CITY OF ALBUQUERQUE

April 20, 2015

RE: **Chick-fil-A**
1600 Gibson Blvd SE
Grading and Drainage Plan
Engineers Stamp Date 3/18/15 (M15D012C)

C-3.2

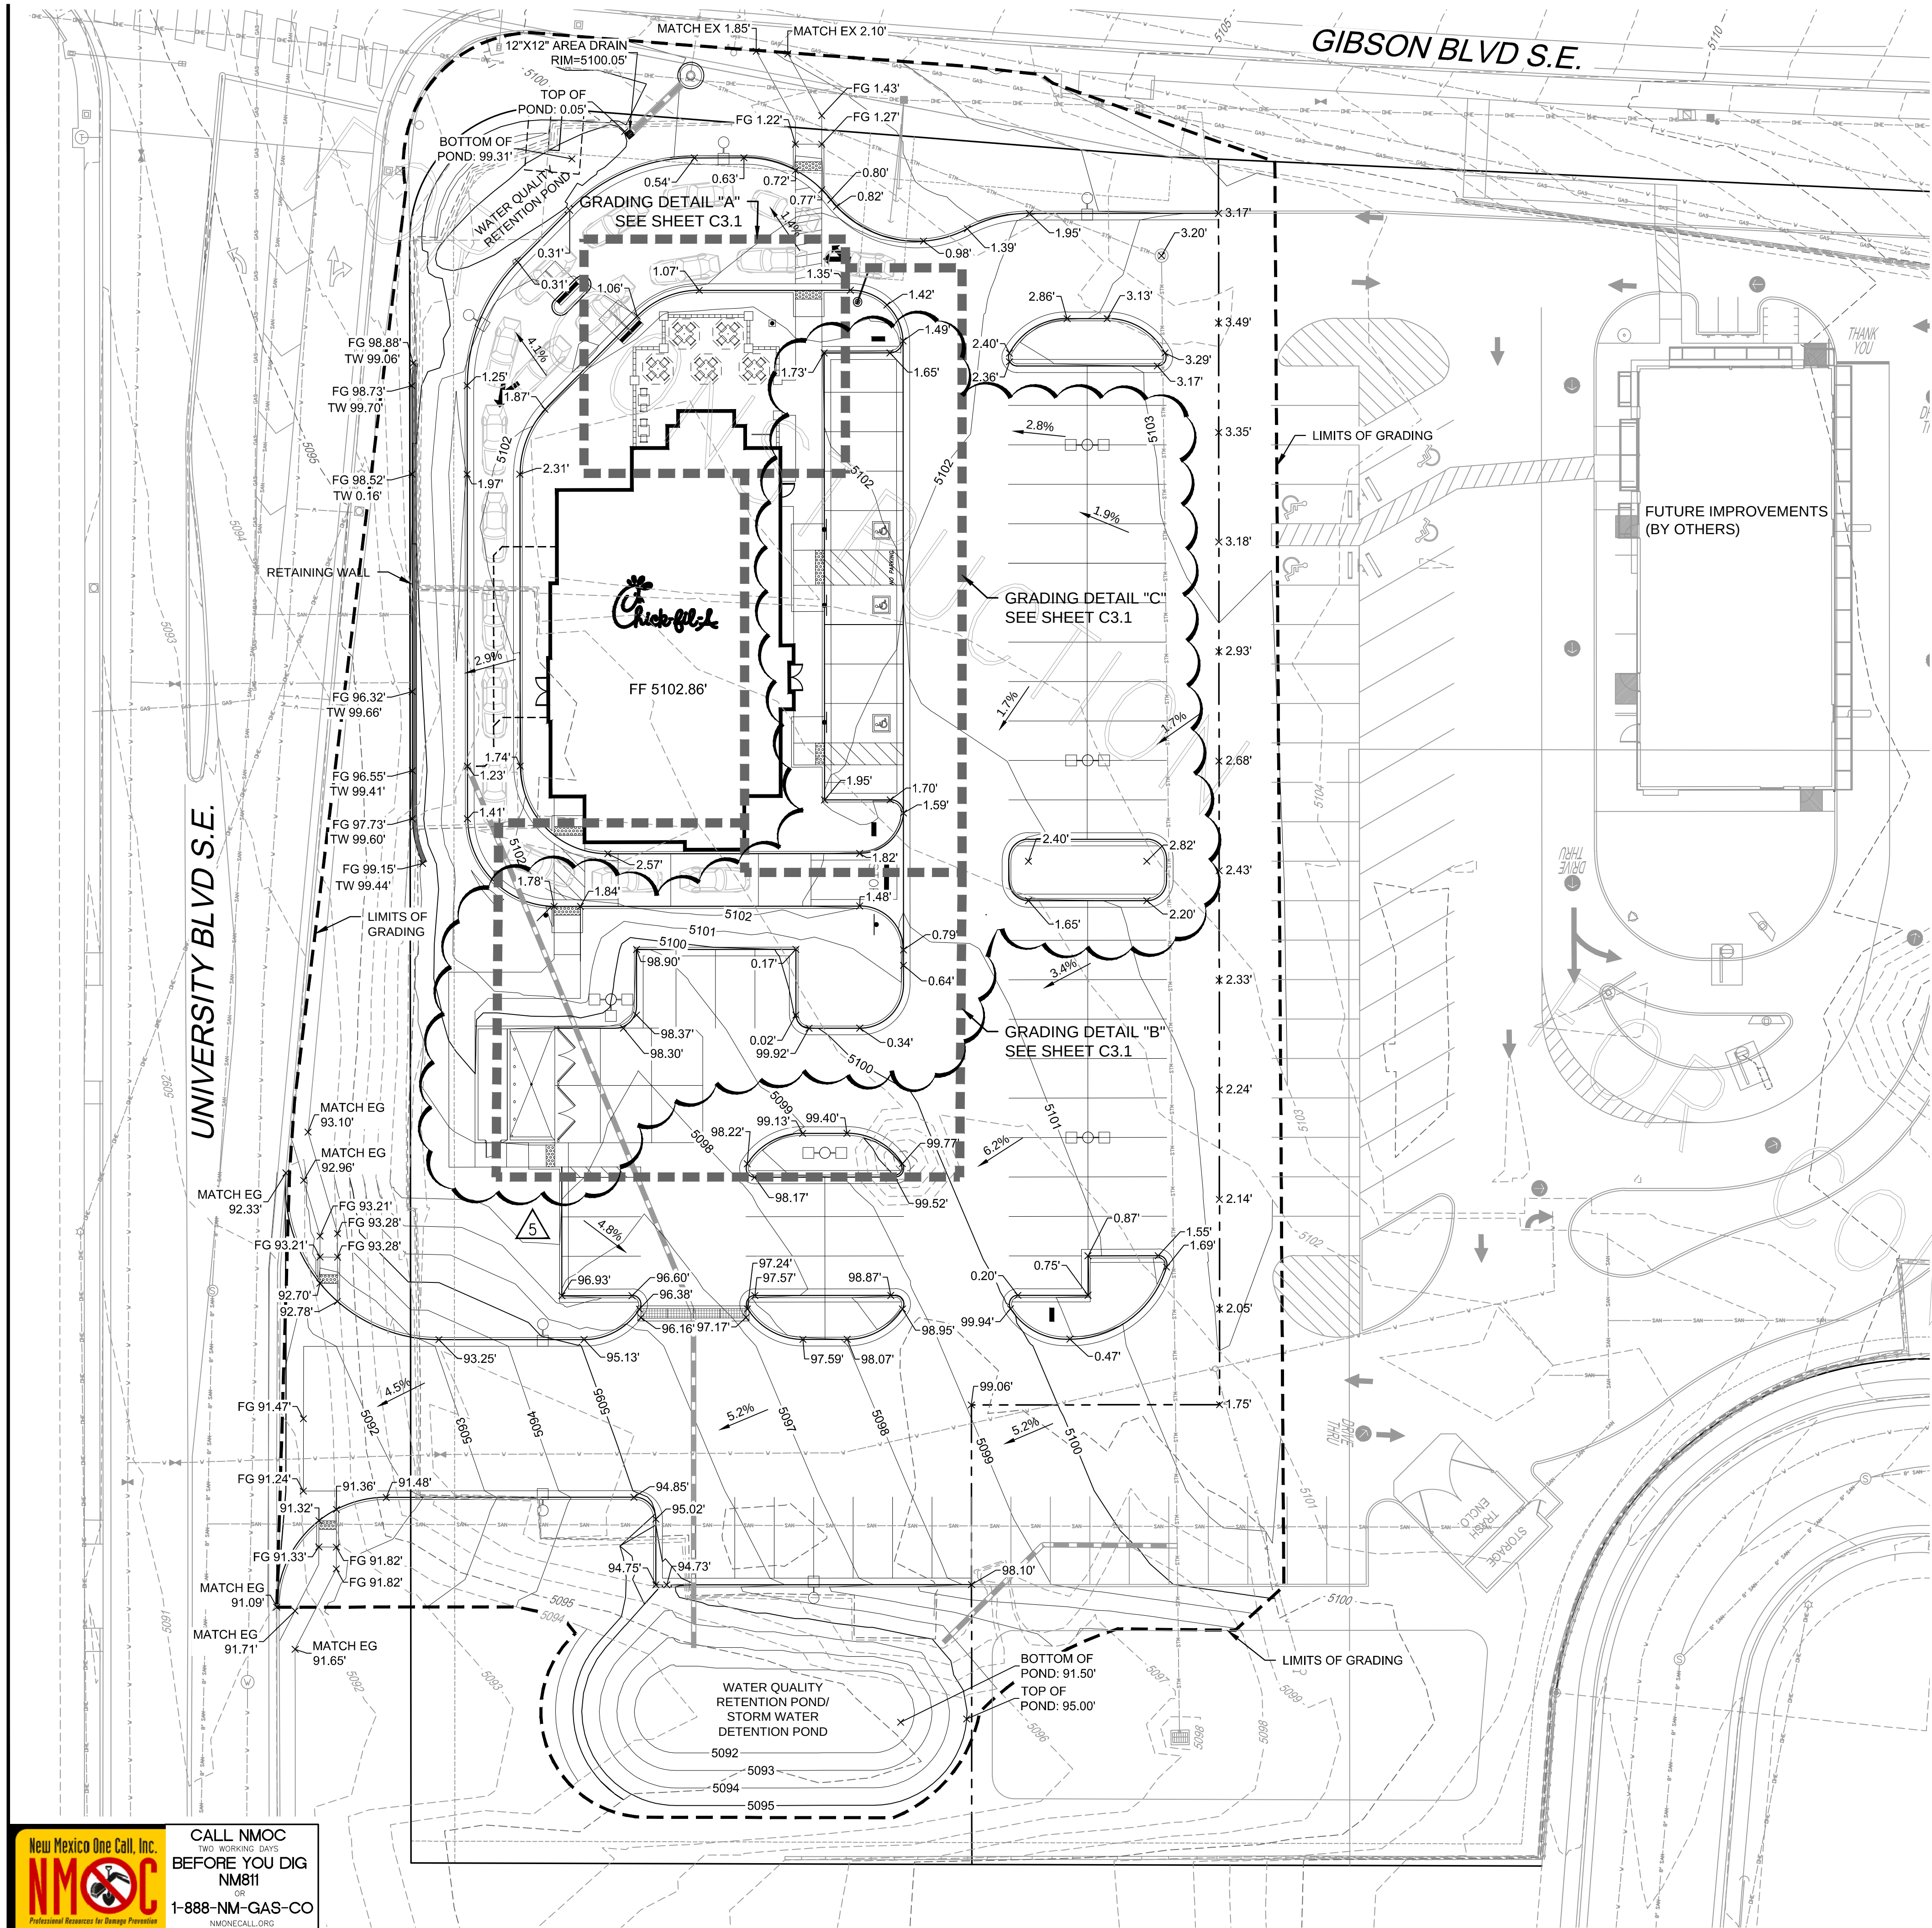
- c. Provide hydraulic calculations and profile graphic of the existing Storm Drain showing Q, HGL, and velocity. Indicate if the values shown are for this site only, or include the flows from site to the east.

5. Indicate what the Discharge to University is and what is allowed. Provide the drainage file # of any References or supporting documentation. Provide any excerpts.

Sheet
C-3.0

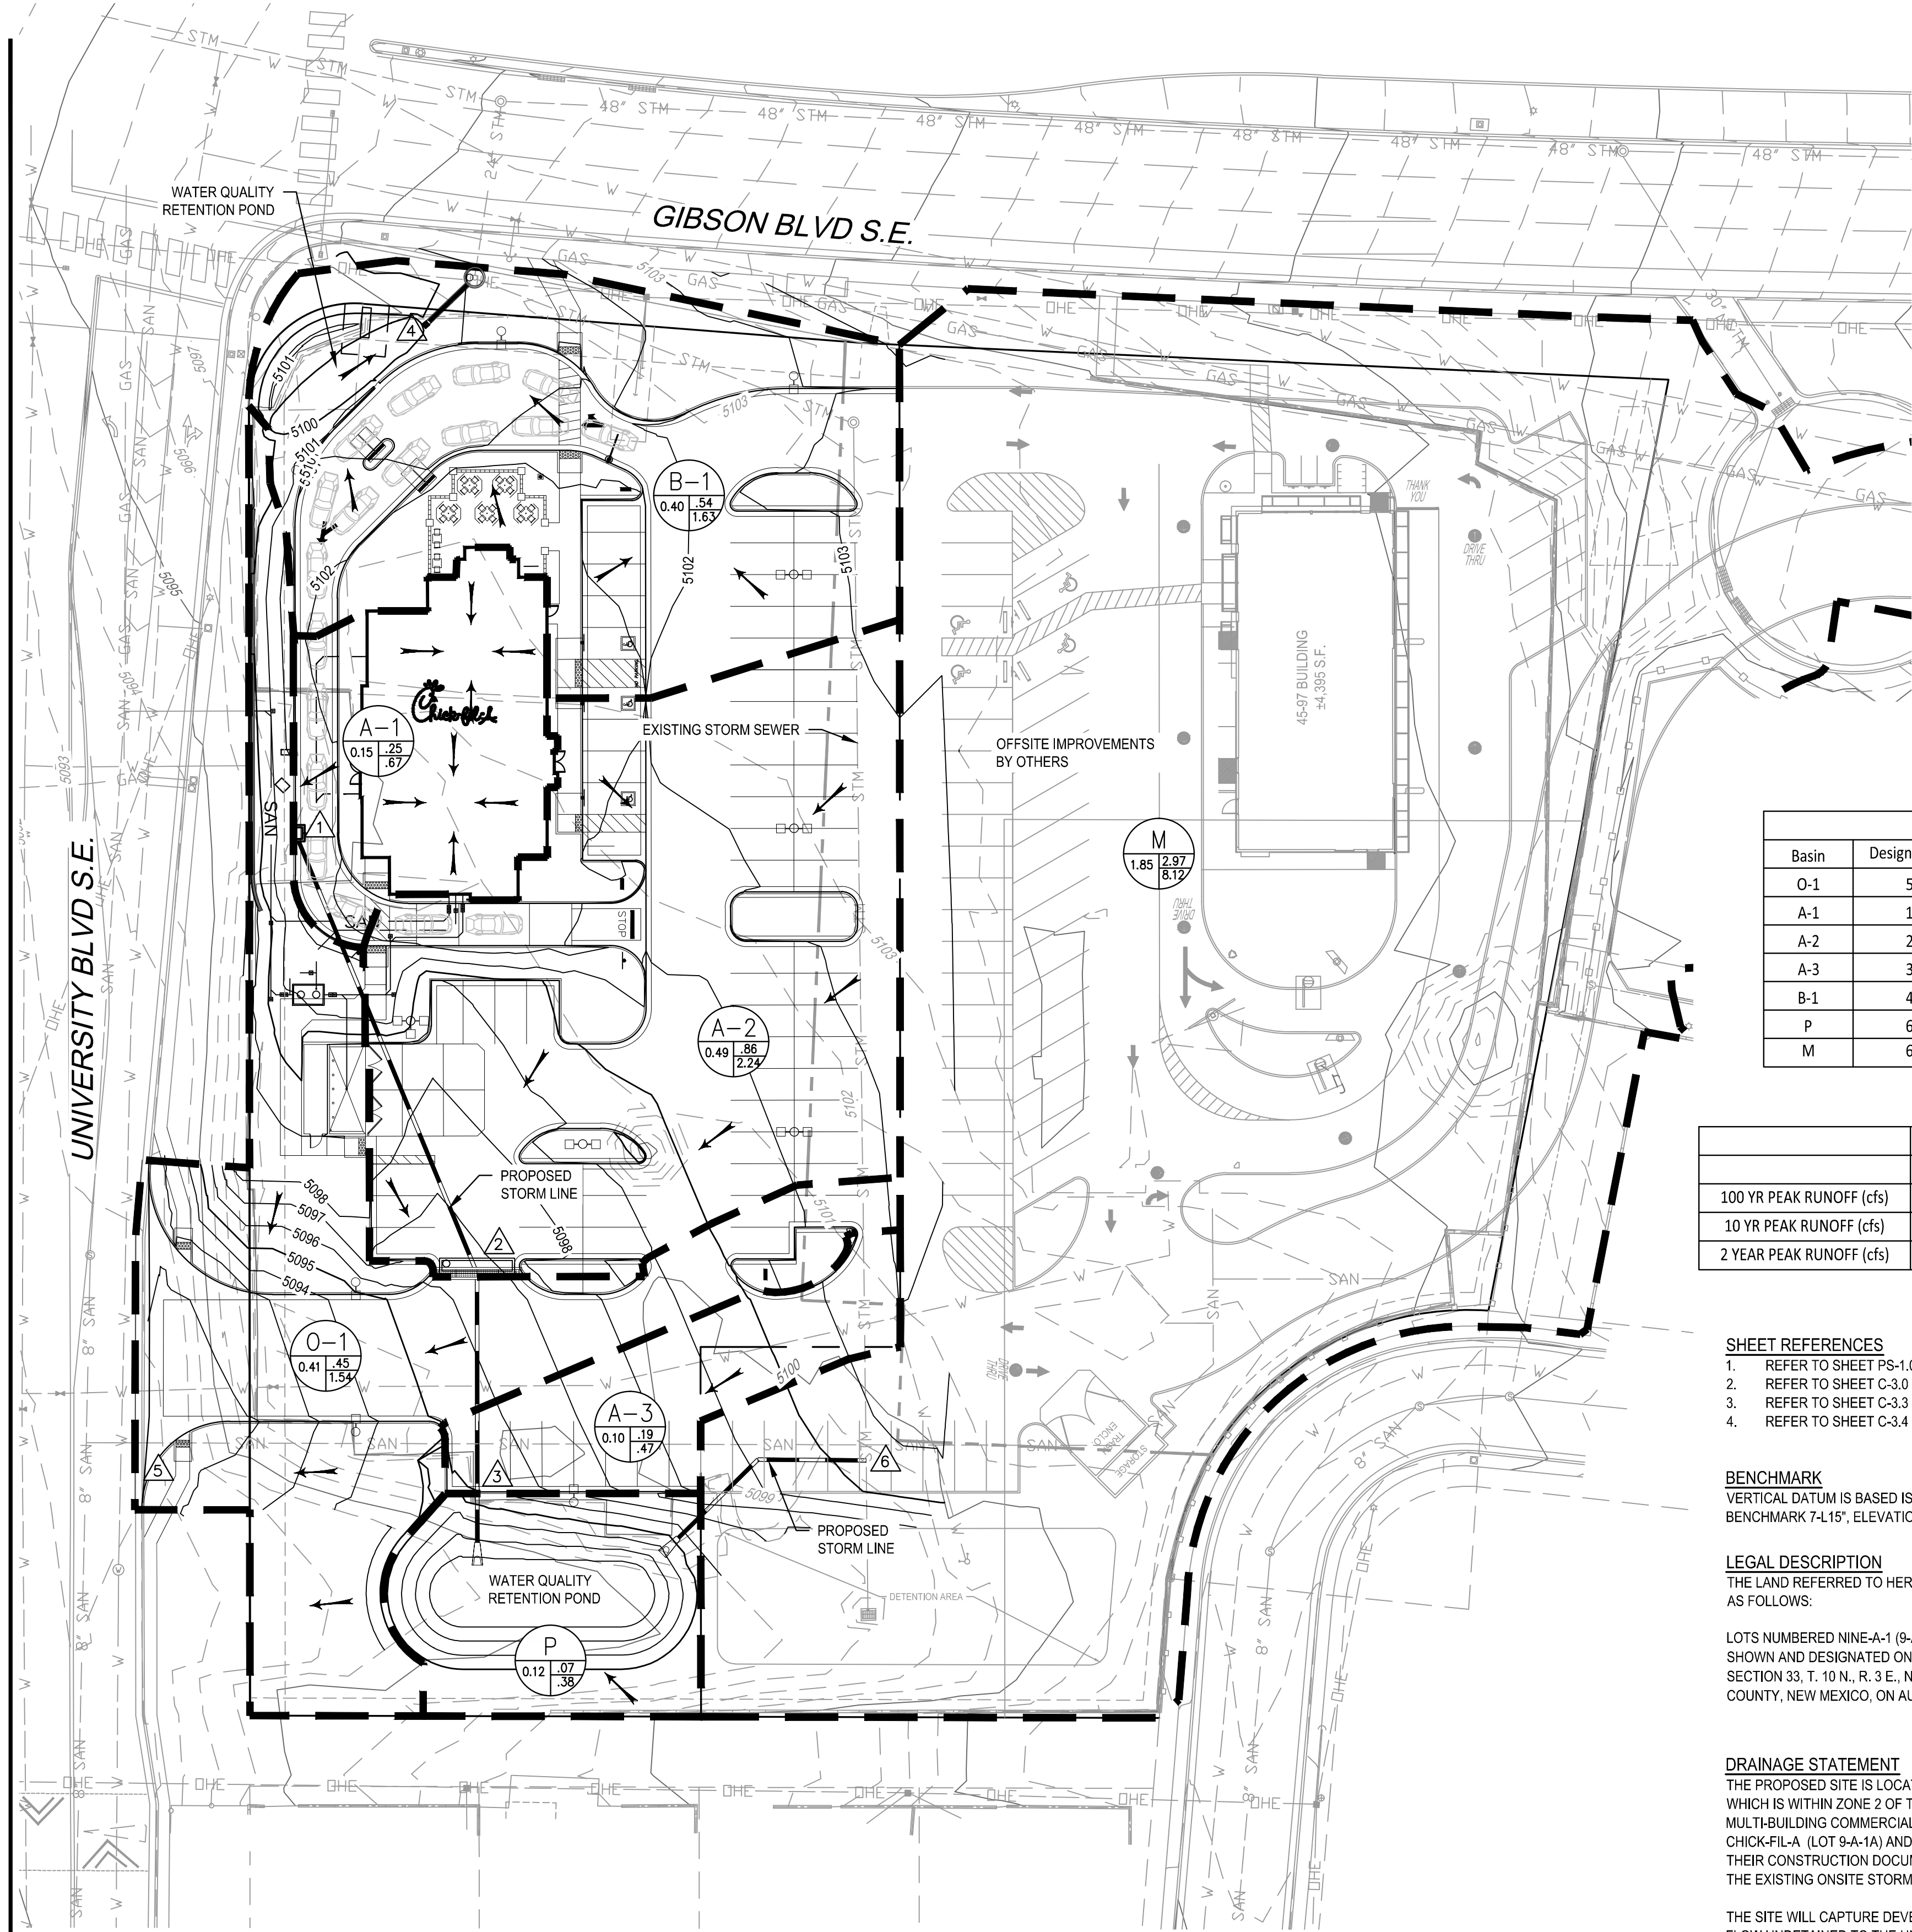
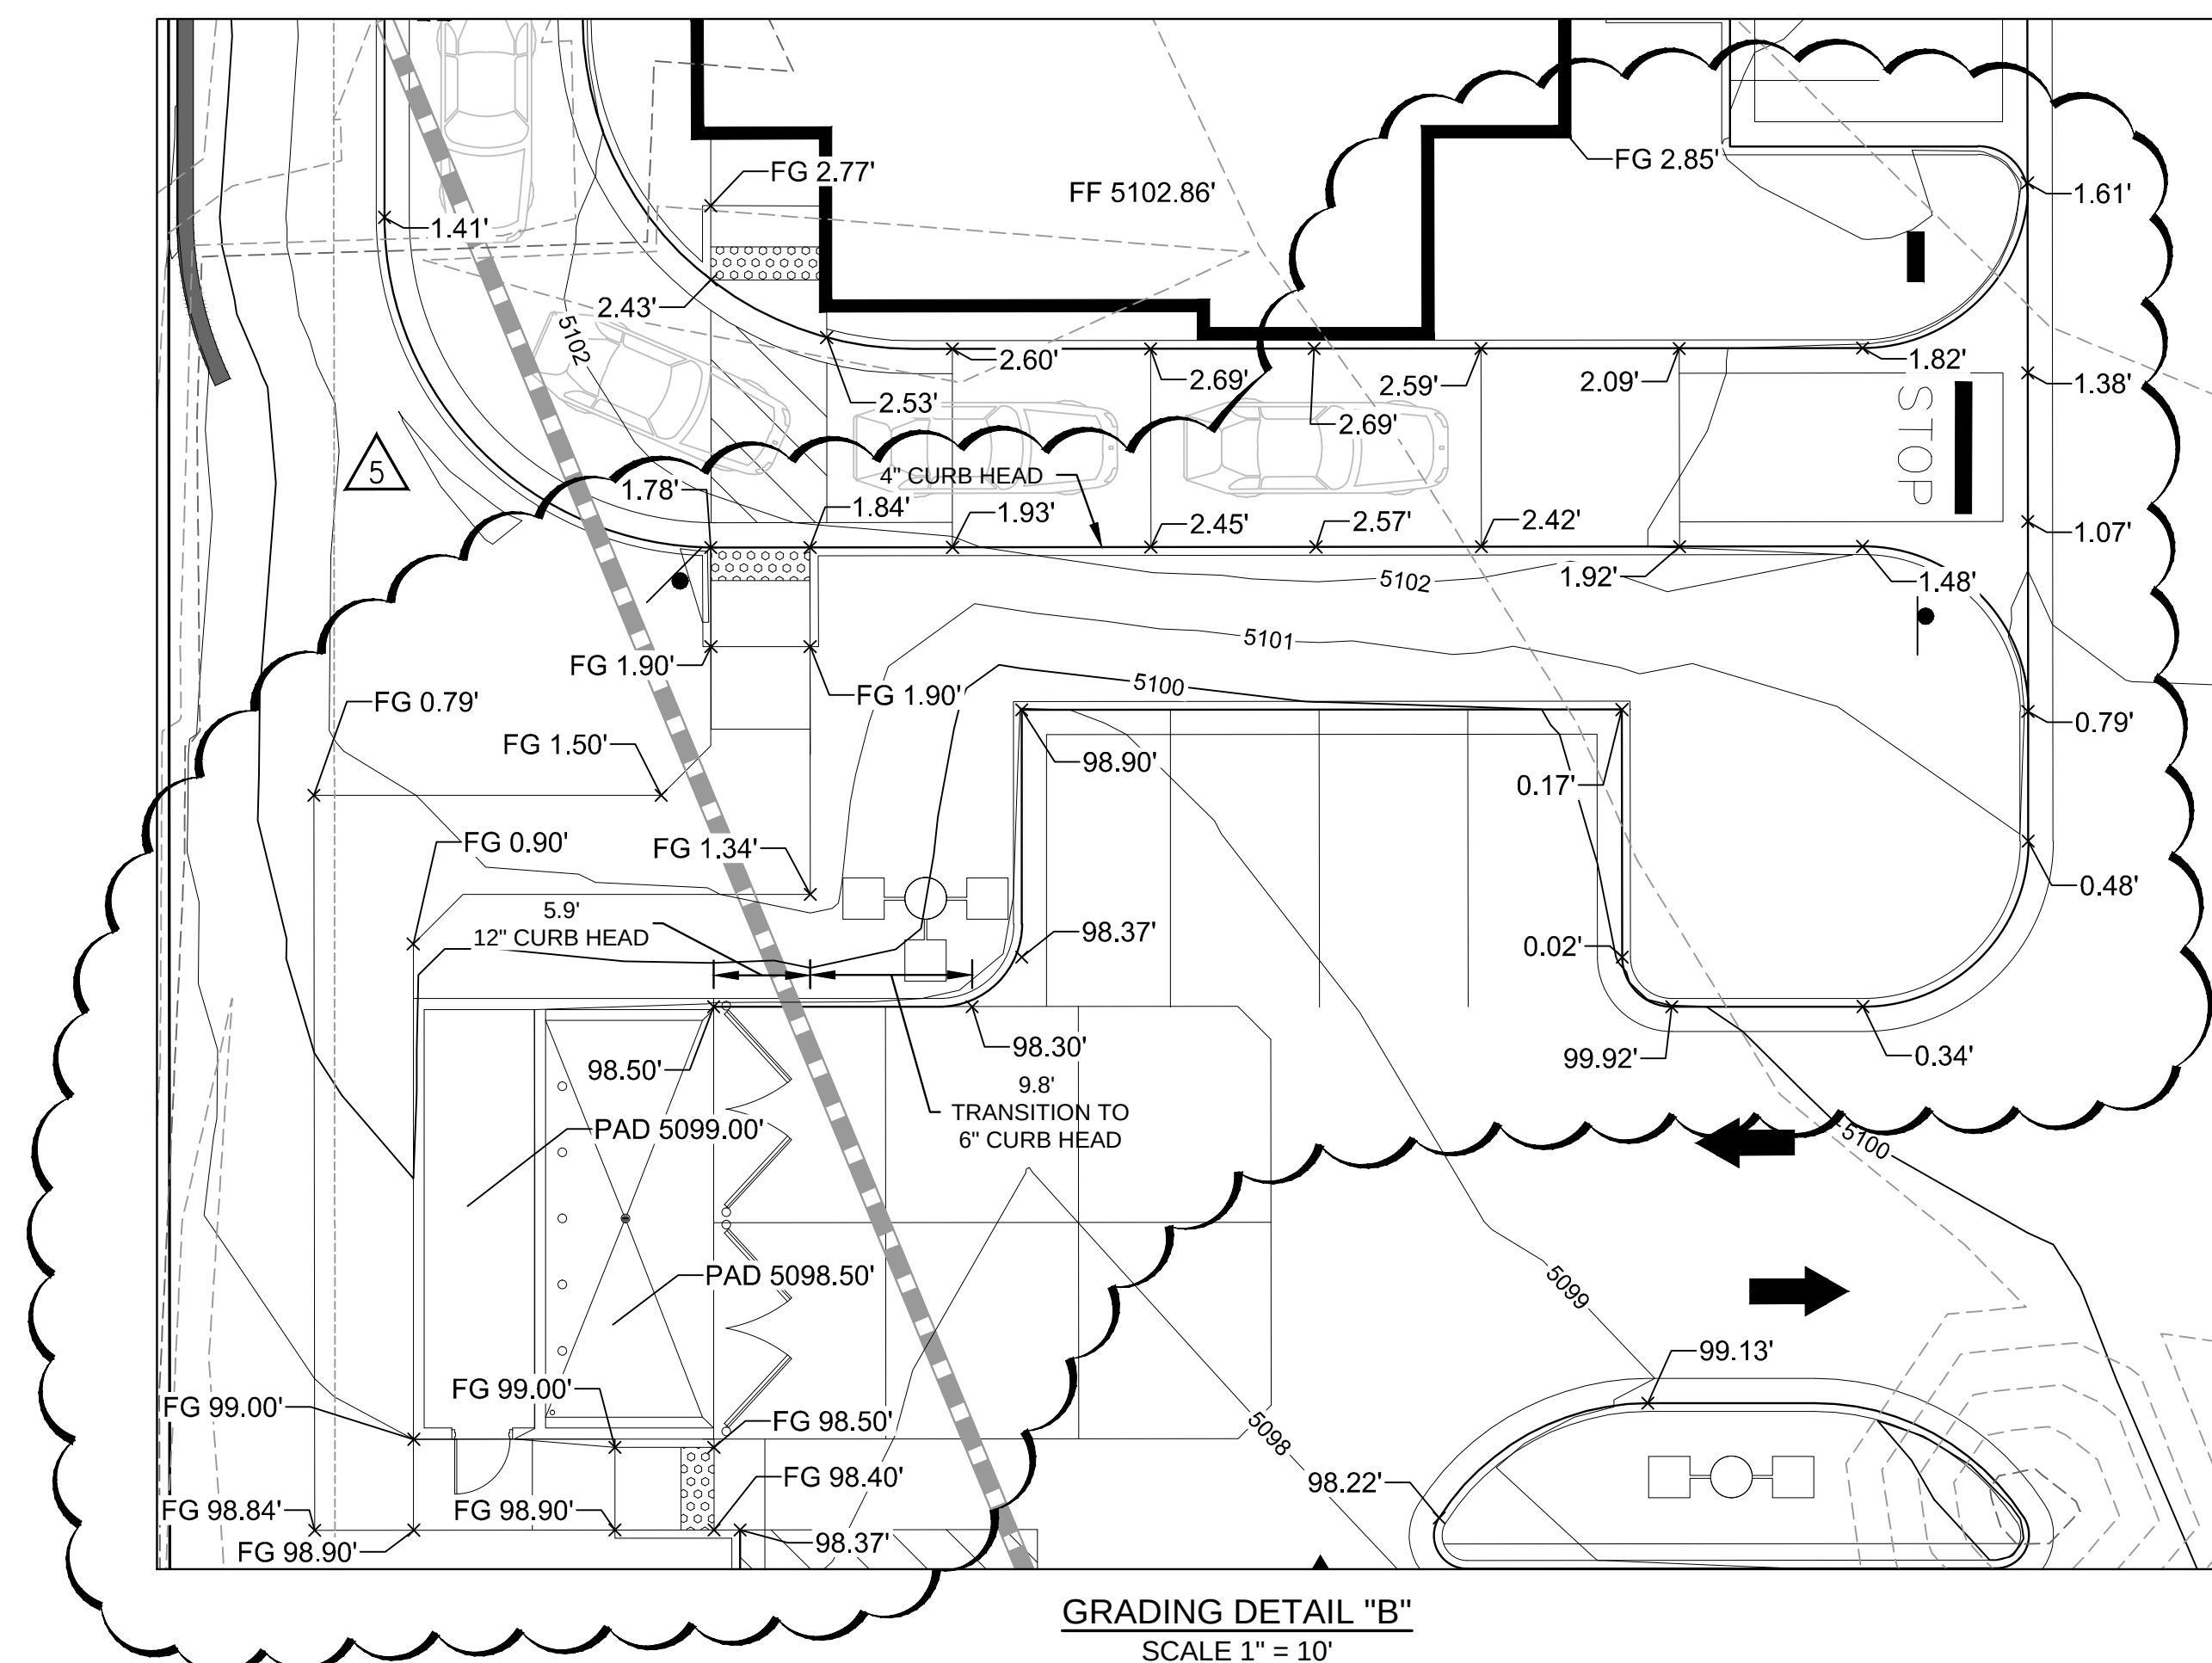
- d. Provide a connection detail to the 21" storm drain.
2. Verify Pond Bottom Elevation is 92.00 (Sht C3.0). It appears that it needs to be lowered since the invert is at 91.43(Sht C3.3).

3. There is an existing storm drain and inlet just north of the proposed storm drain. Please indicate if these items are to be removed or will remain.
4. Since the pond is intended to drain via the existing storm drain, be sure to note it as a detention pond.
